# CITY OF ALBUQUERQUE

December 14, 2016

RE: **Kiddie Academy**  
**Grading and Drainage Plan**  
**Engineer's Stamp Date 11-14-2016 (File:C19D061)**

GRADING & DRAINAGE PLAN

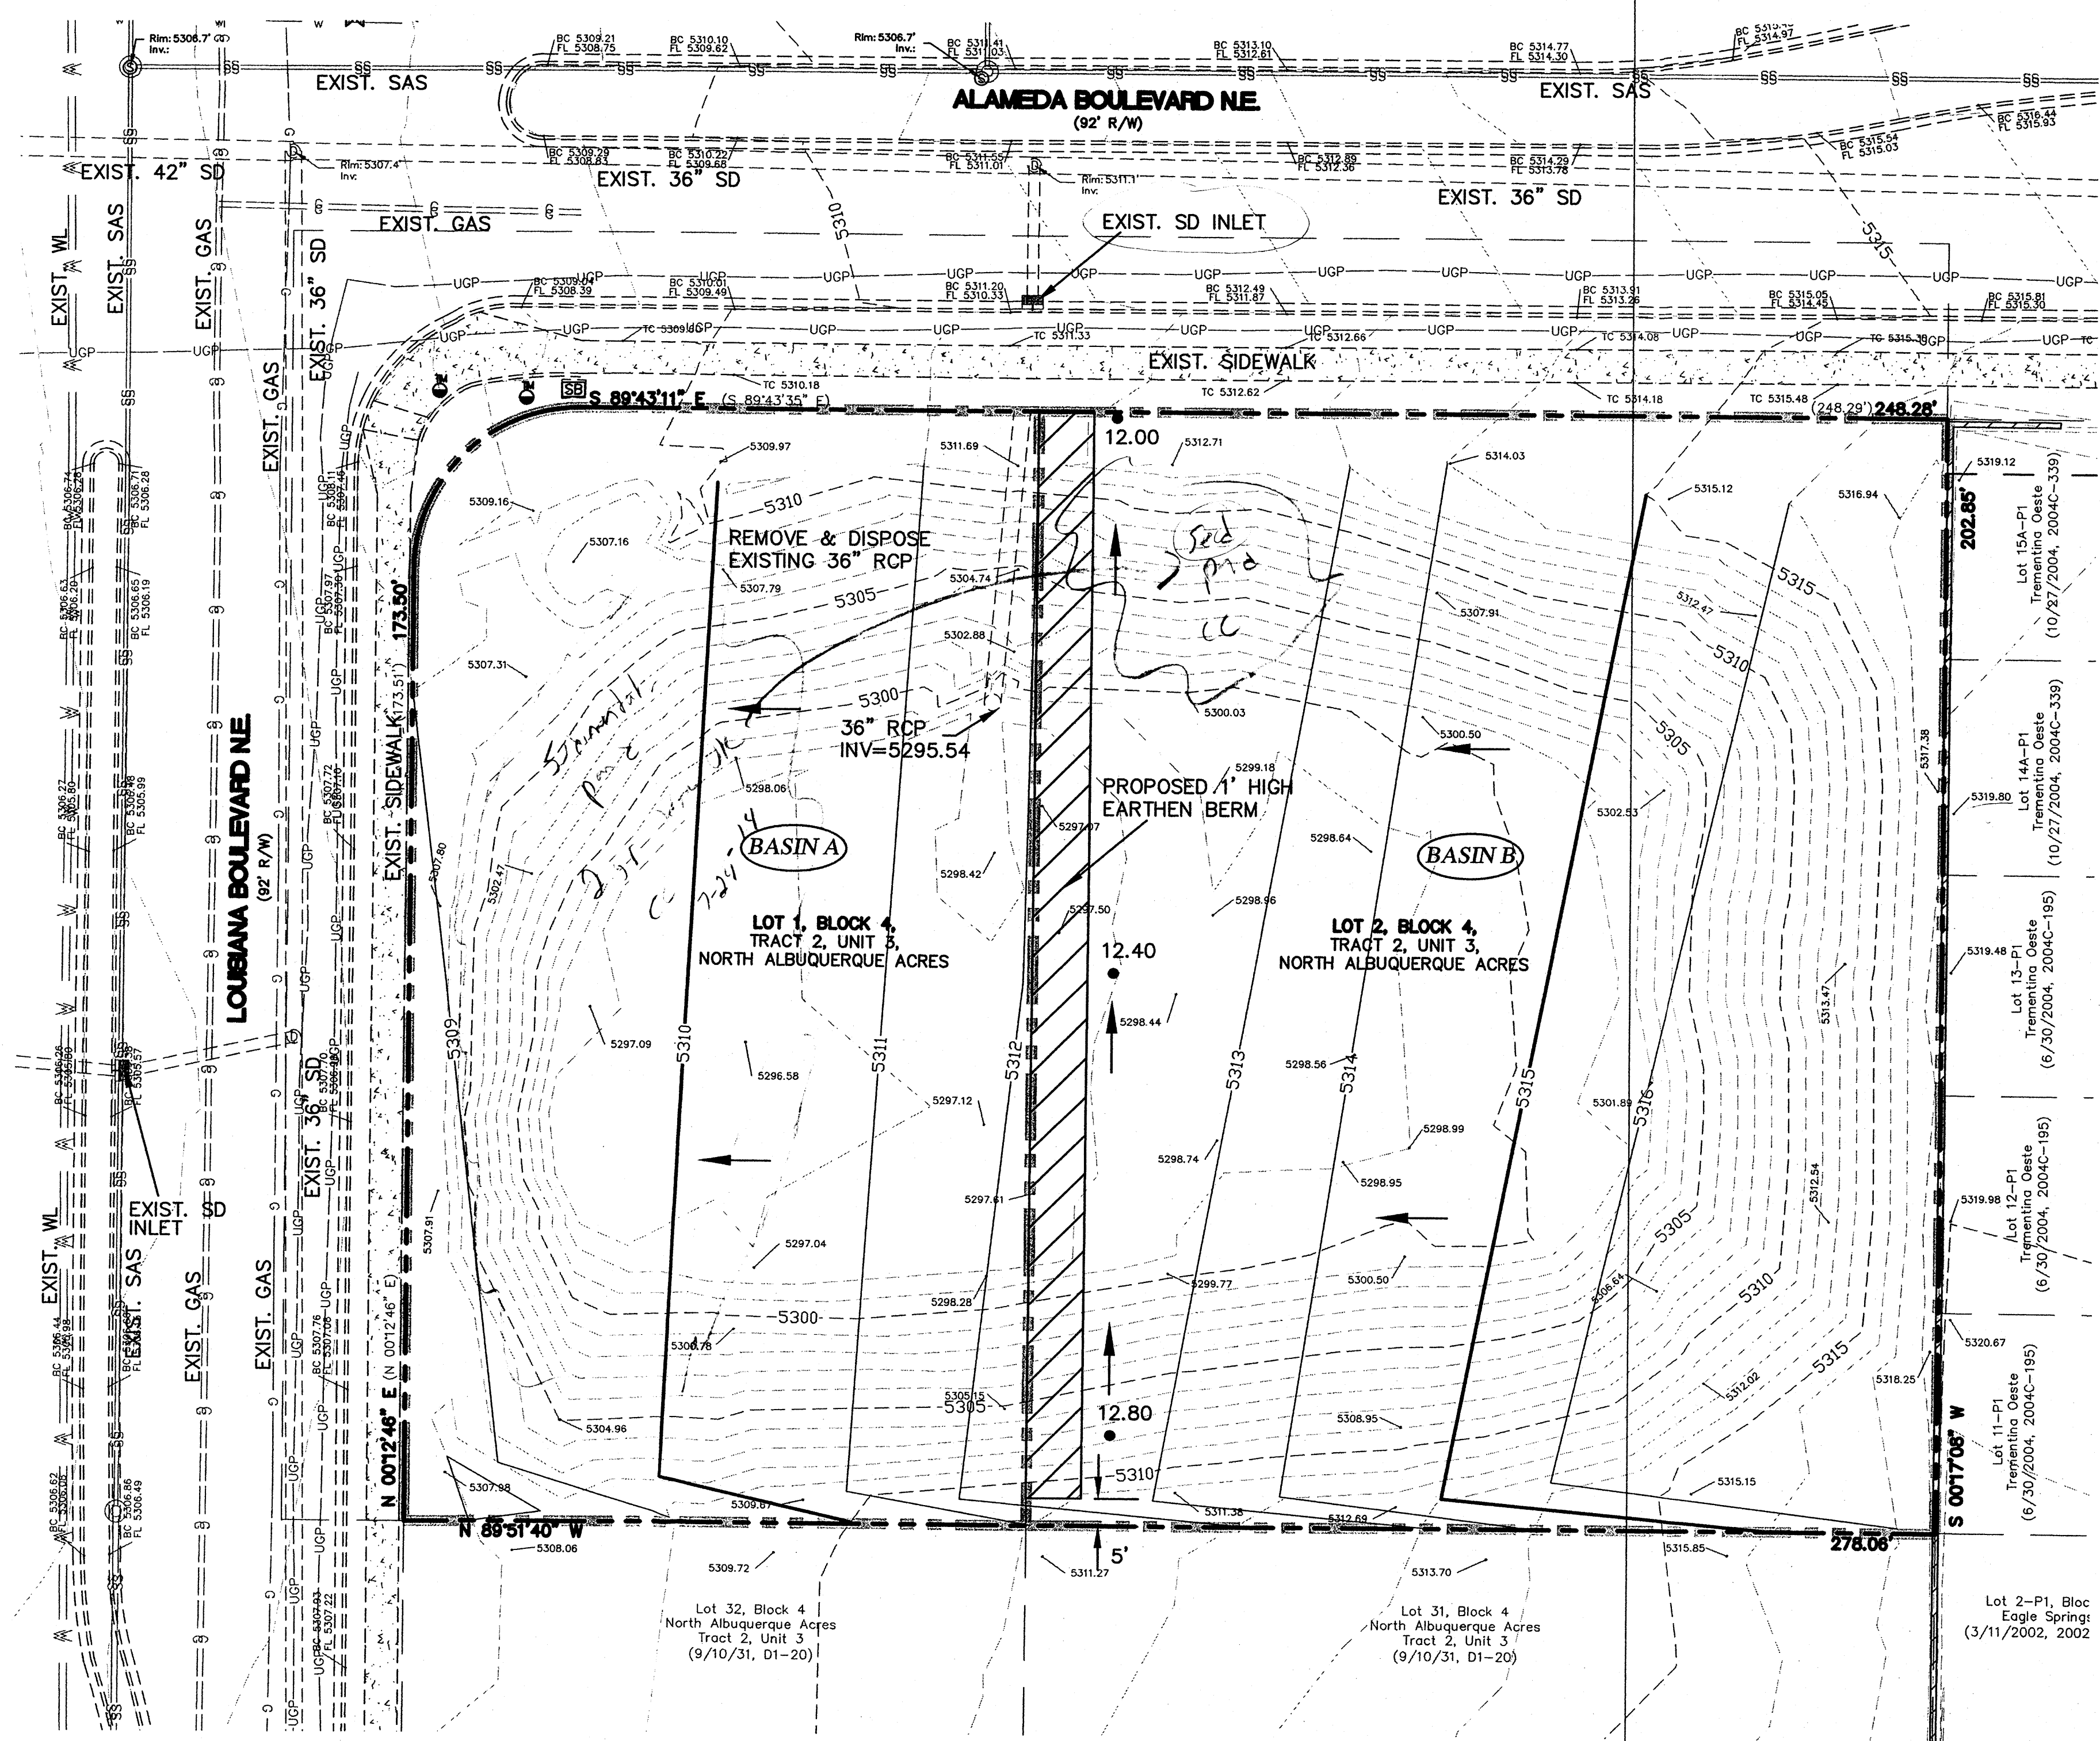
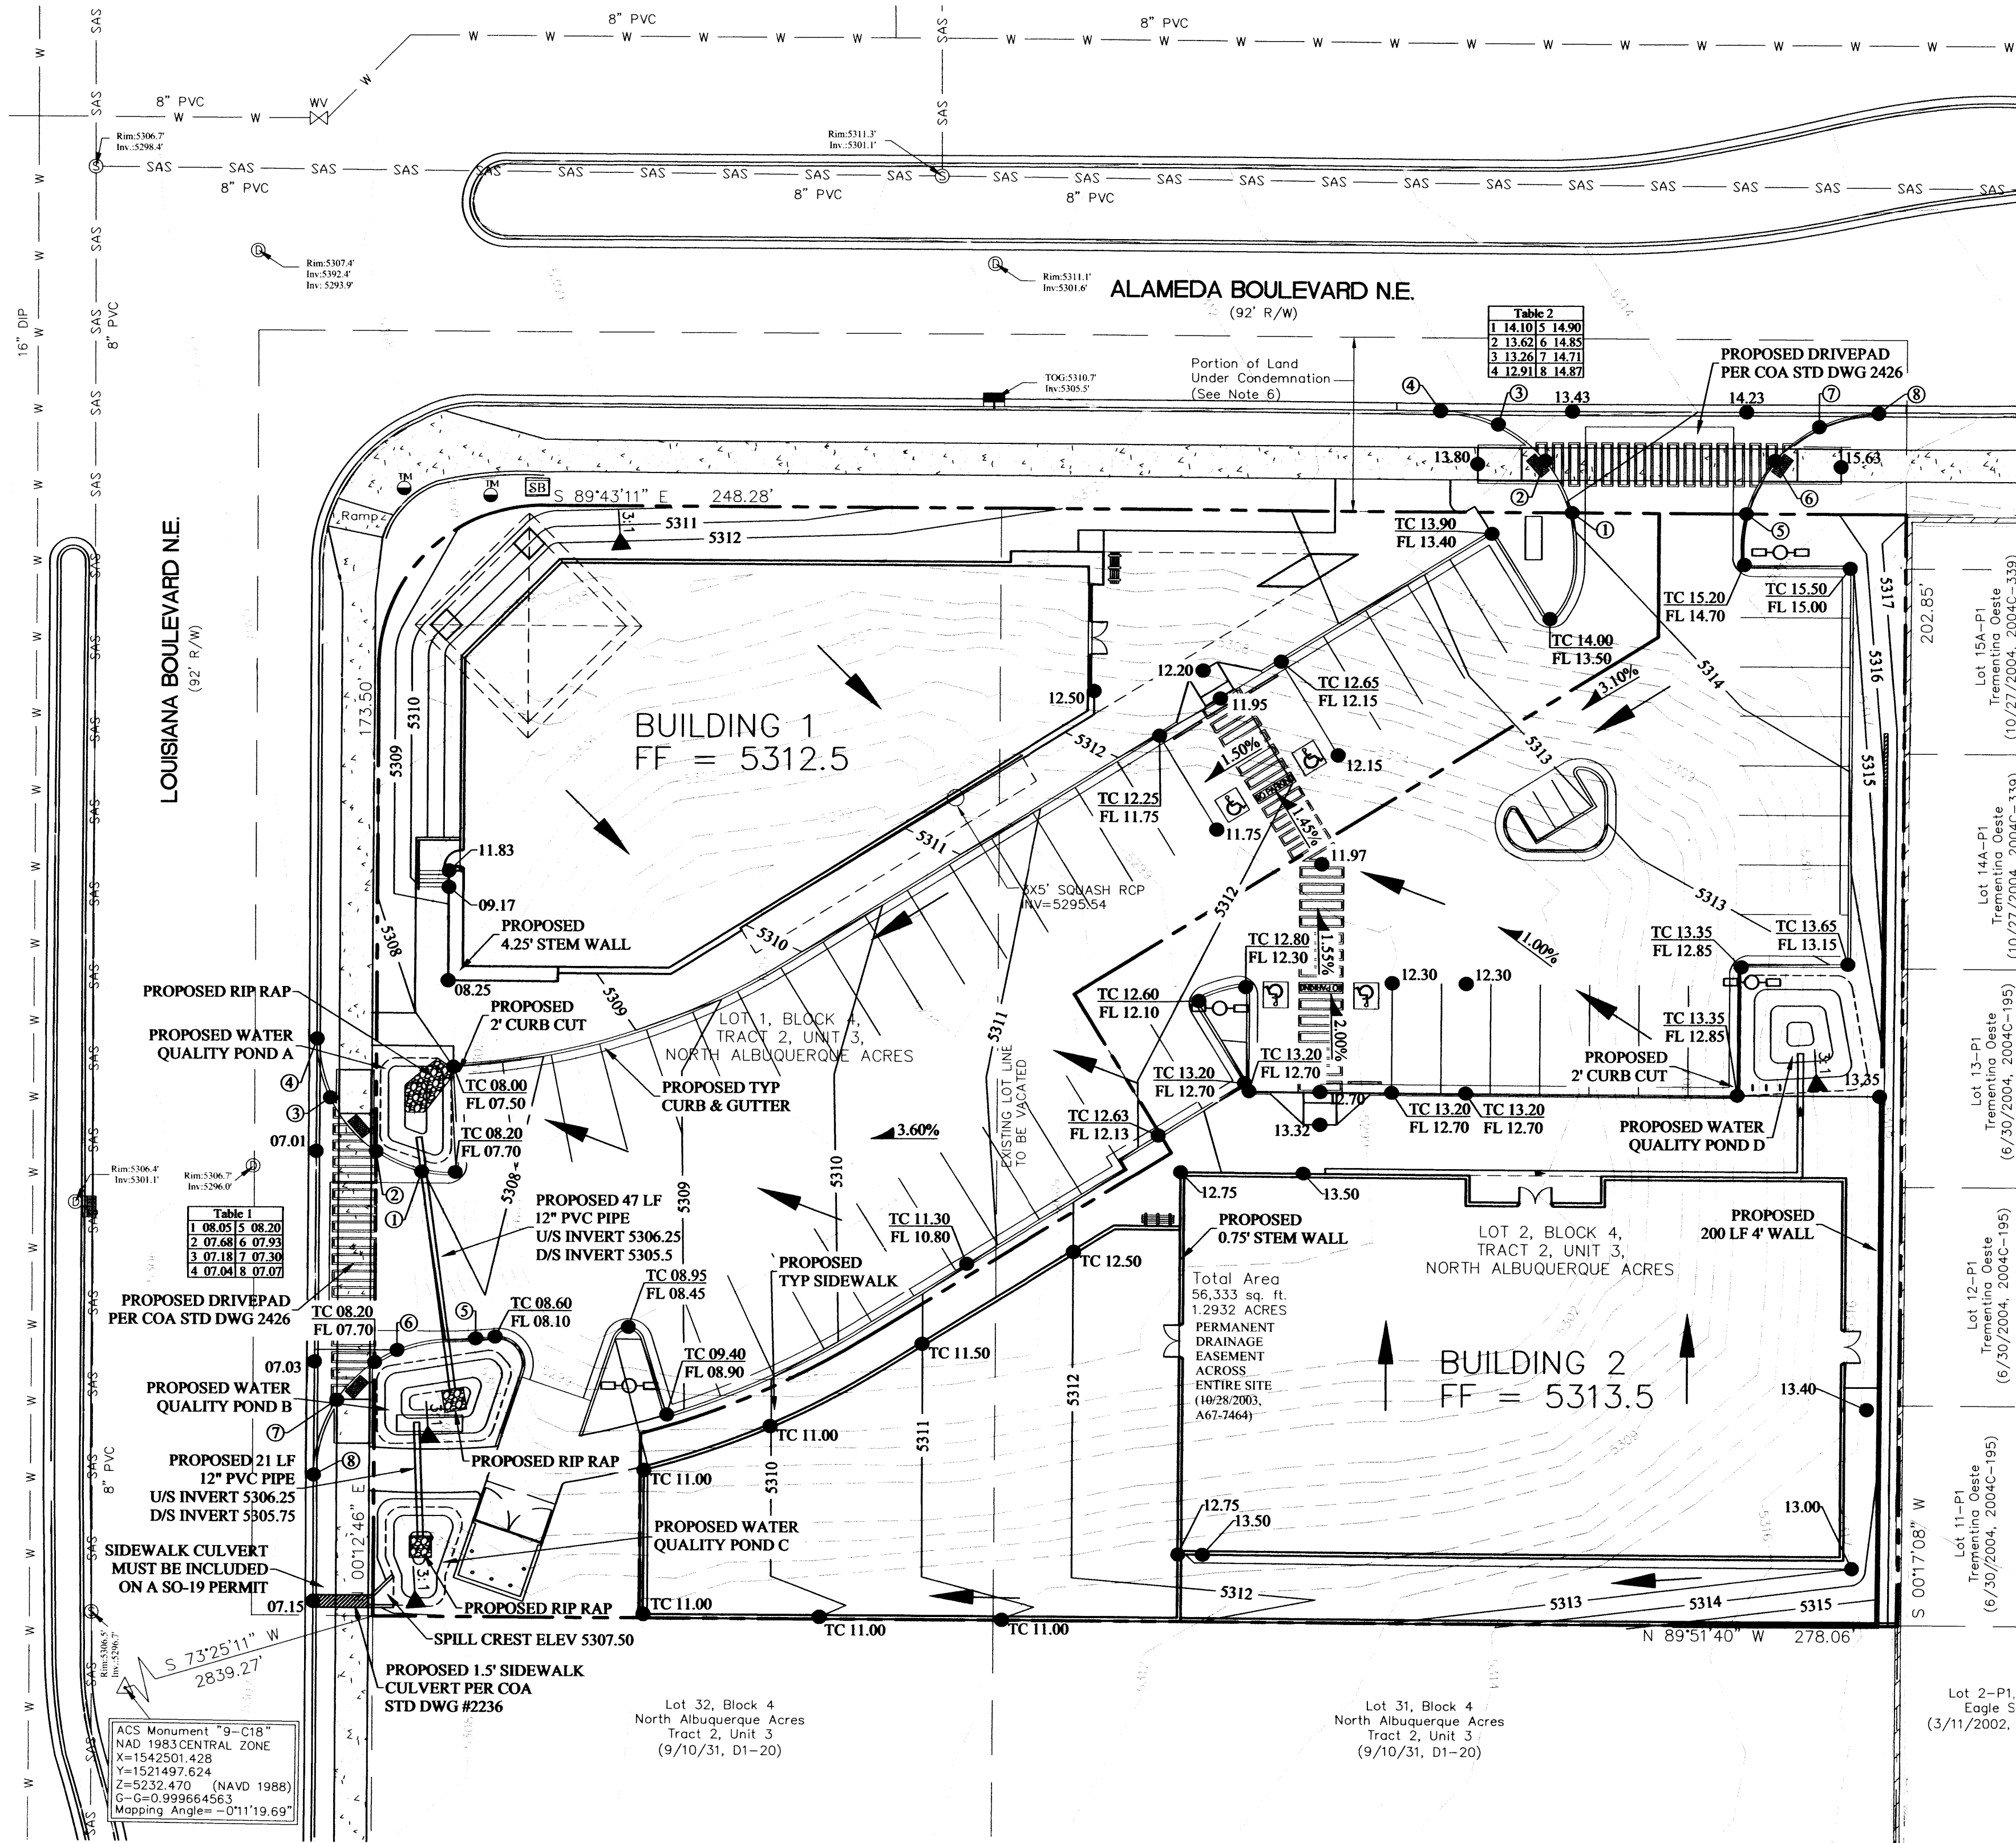
One comment I will have for Building Permit is that you will need a crosslot drainage easement over the western lot/tract for the benefit of the eastern tract/lot since the entire site drains to the west.

*took care  
of it @ 4/12/14/16 DRB*
